Subject: **Wilcannia Weir Replacement (SSI-10050) – Environmental Impact Statement**

Detailed advice to DPE Planning & Assessment regarding the Wilcannia Weir Replacement (SSI-10050) – Environmental Impact Statement

Figure 1-2: Key design features of the proposal – new weir site (overview)

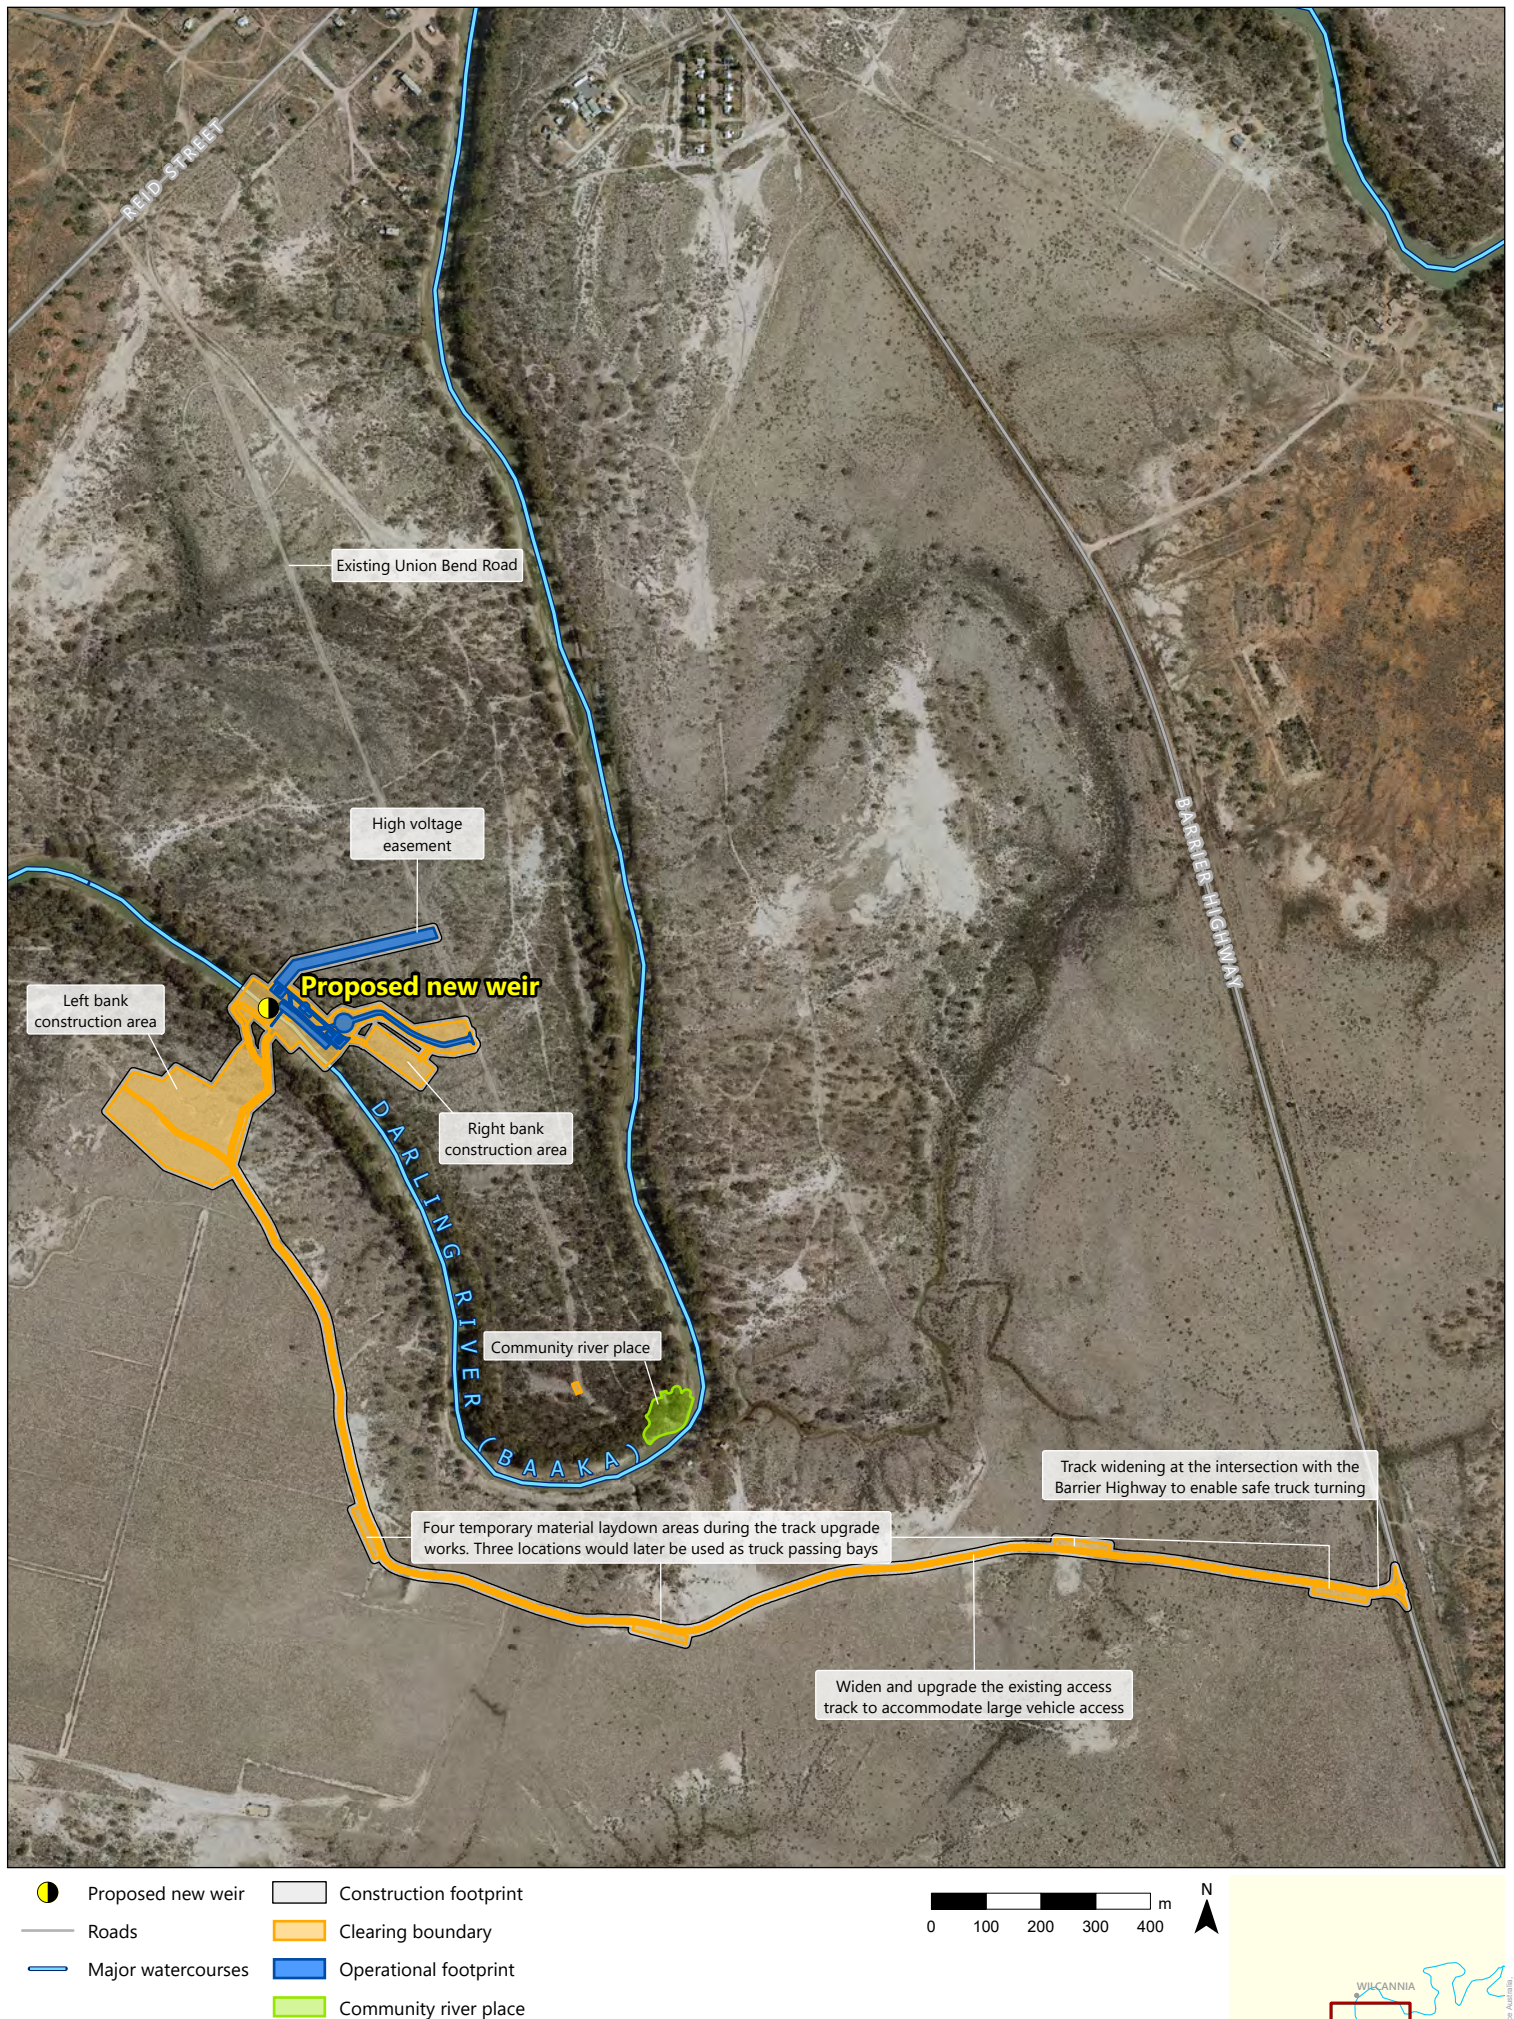
The proposed fishway appears to be designed with an outlet parallel to the bank. We are concerned that this design may cause scour of the bank. The end of the fishway should be

directed into the centre of the watercourse to minimise scour. Appropriate scour protection should be provided where required.

- confirm design of the fishway weir will not result in scour of the bank. If scour is a risk, design the fishway to minimise impacts and ensure appropriate scour protection is provided where required.
